Addendum No. 1

RE: Contract ID C203351
WBS # 40165.3.FD1
F. A. # BRSTP-1151(6)
Madison County (B-4984)
Bridge #138 over Big Pine Creek on SR-1151

February 18, 2014 Letting

SUPERSTRUCTURE
 CONCRETE PARAPET
 DETAILS

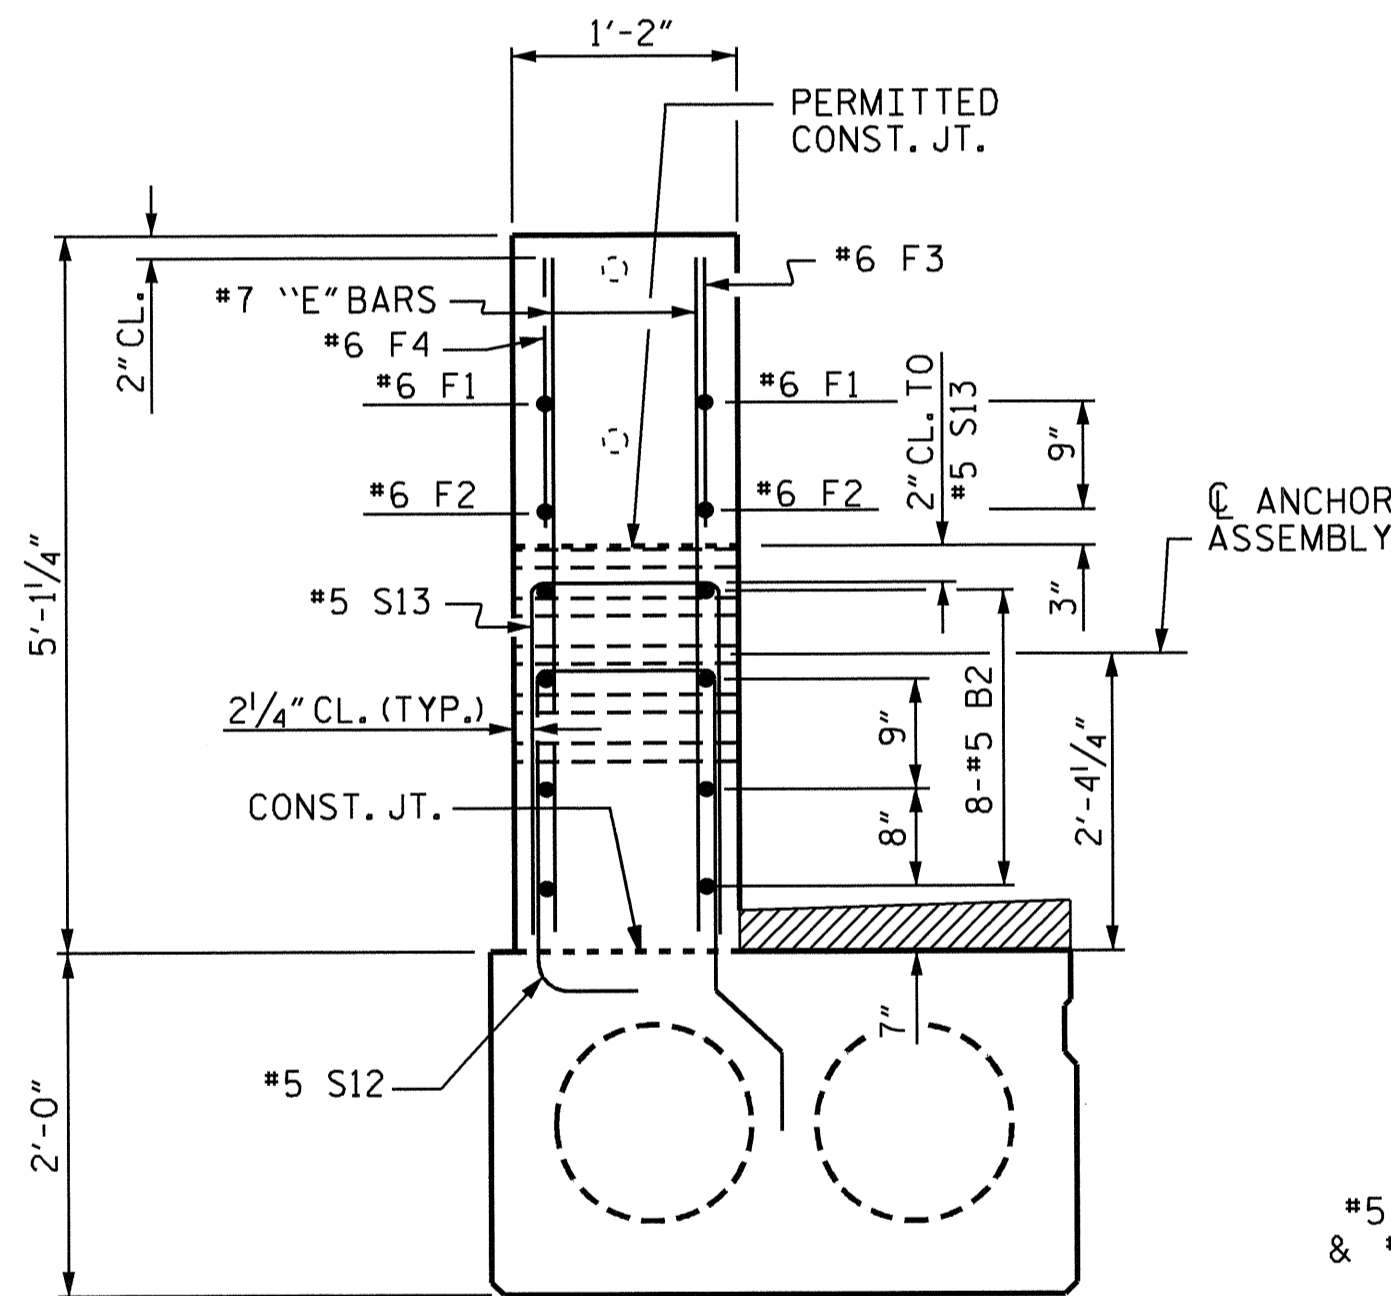
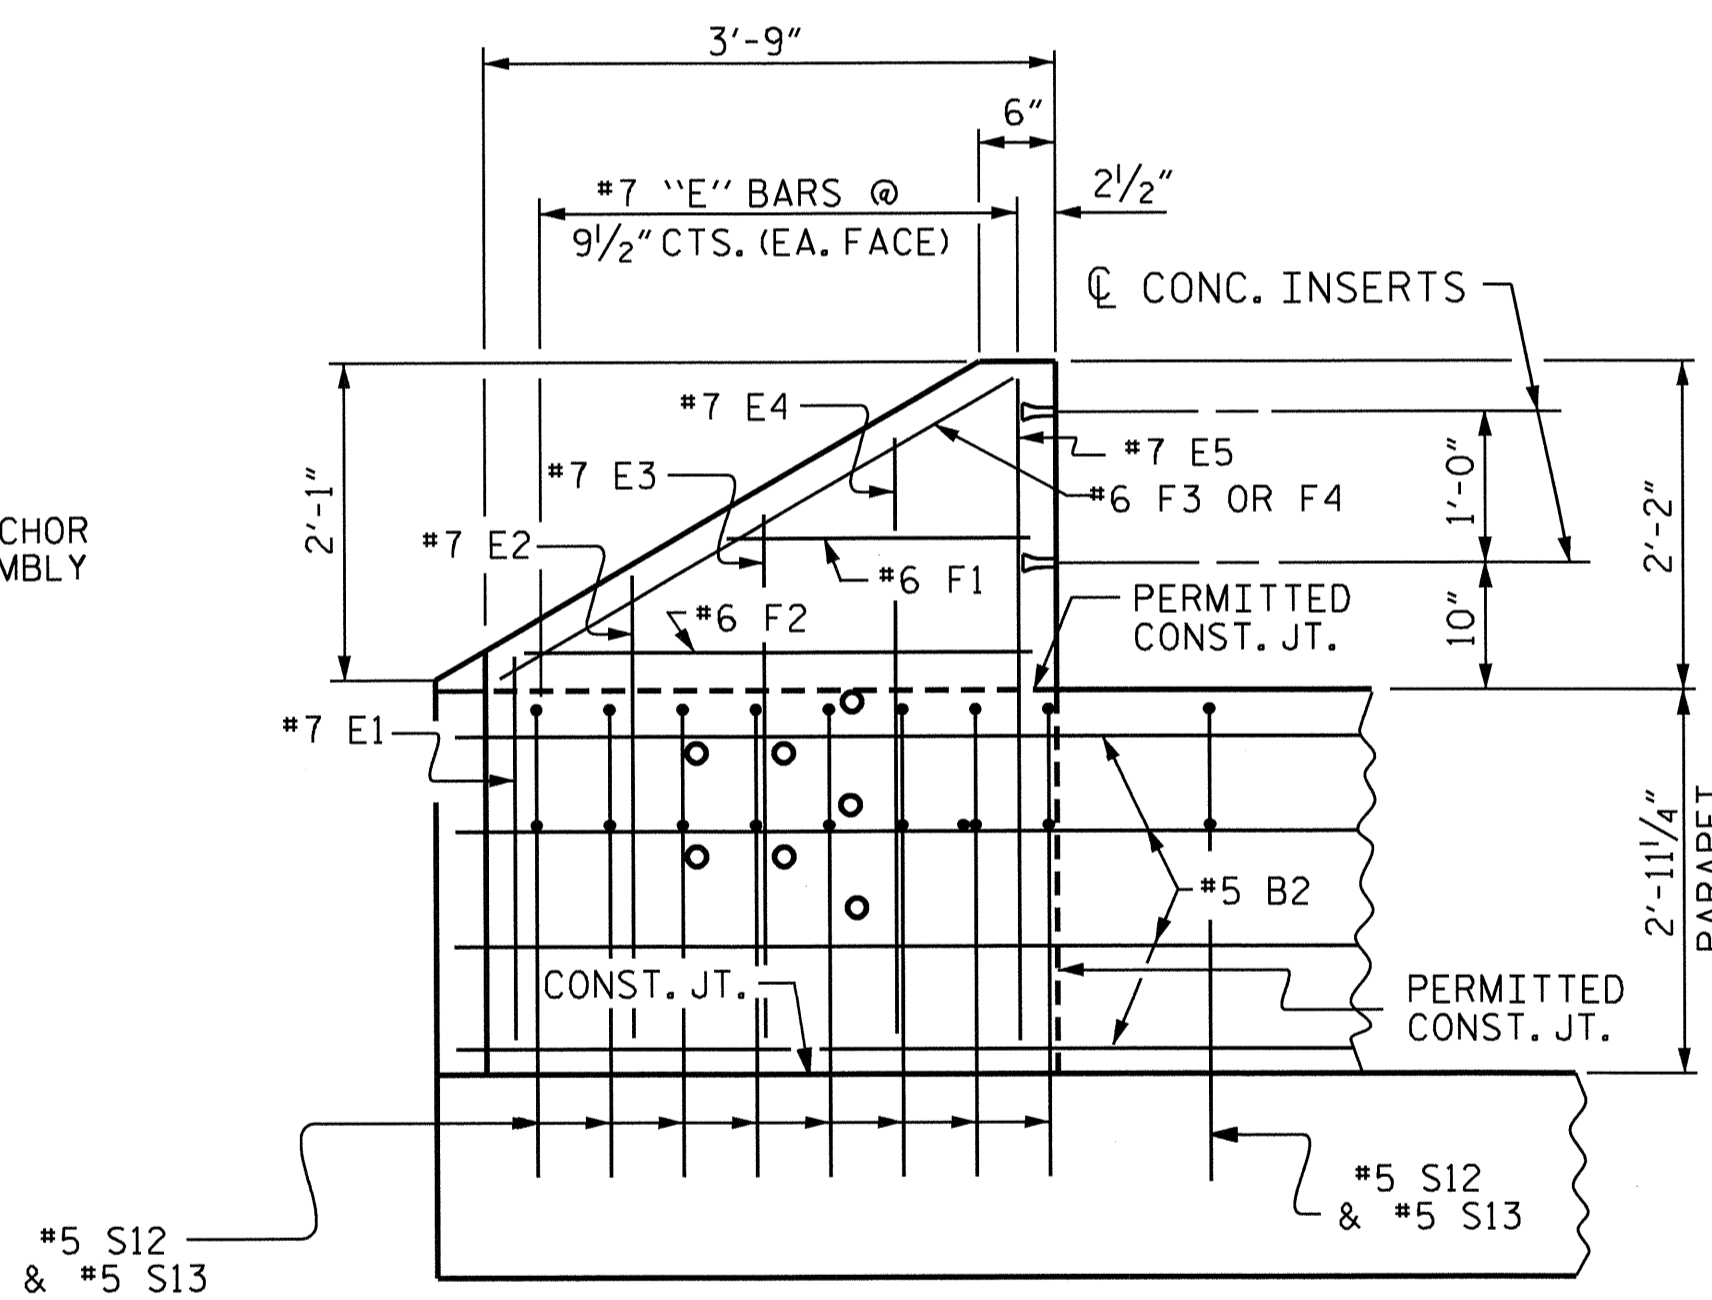
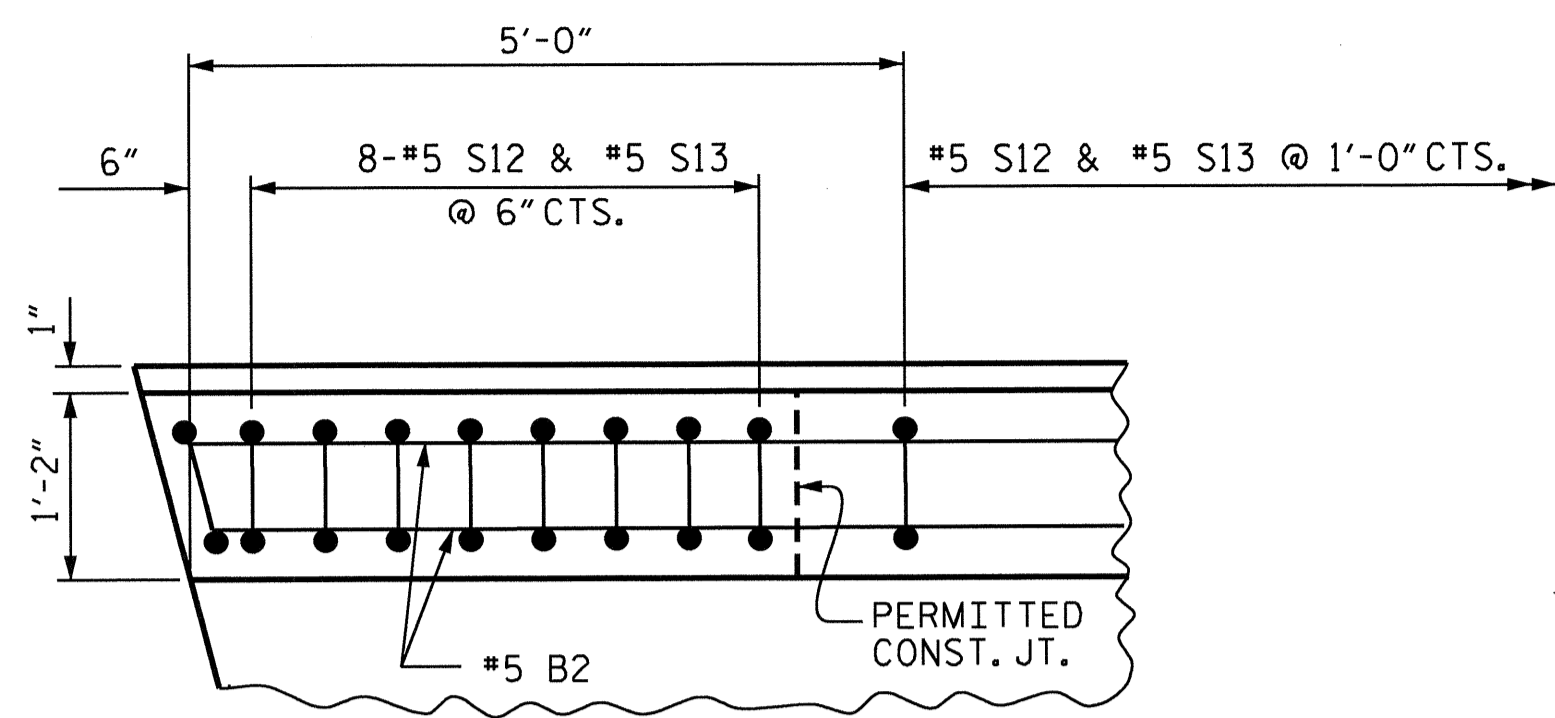
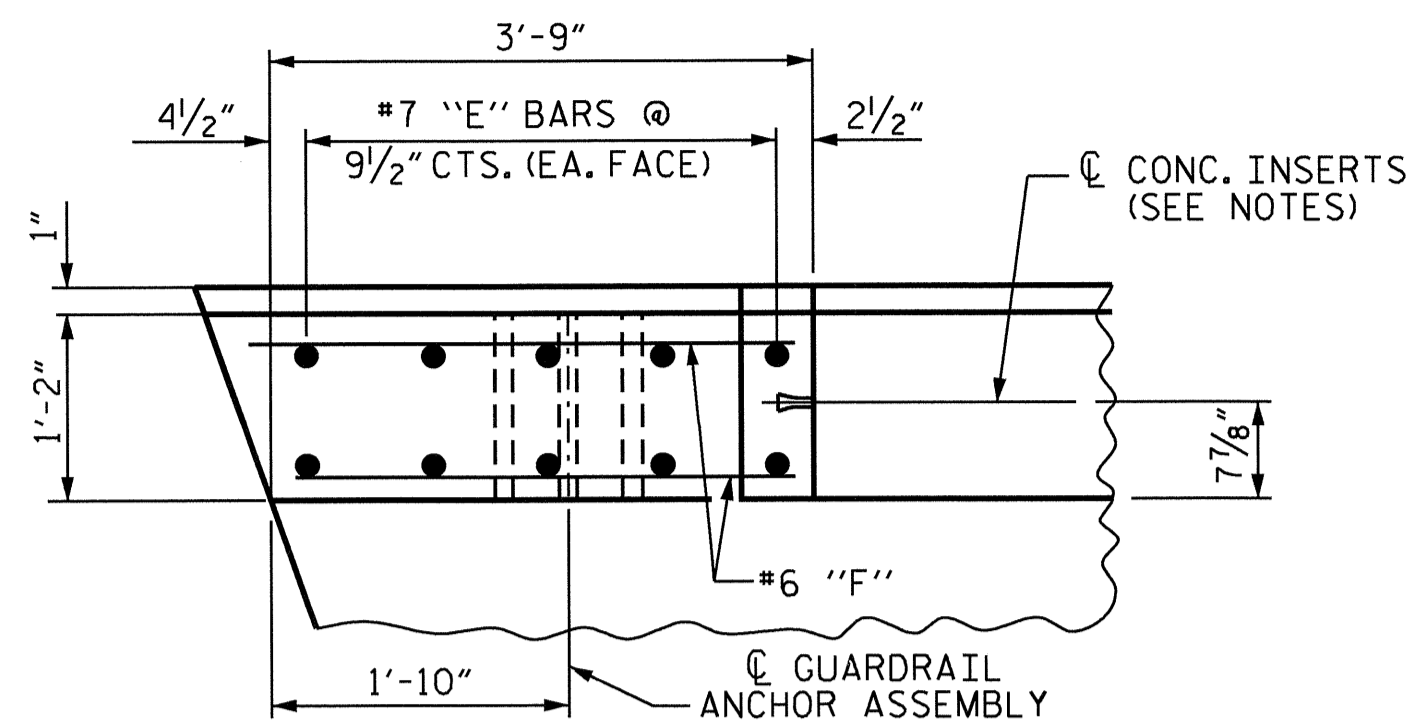
On the item sheets the following pay item has been added:

<u>Item</u>	<u>Description</u>	<u>Old Quantity</u>	<u>New Quantity</u>
109-8517000000-E-460	1'-2" X 2'-11 1/4" Concrete Parapet	NEW ITEM	140 LF

The Contractor's bid must include this new pay item. The contract will be prepared accordingly.
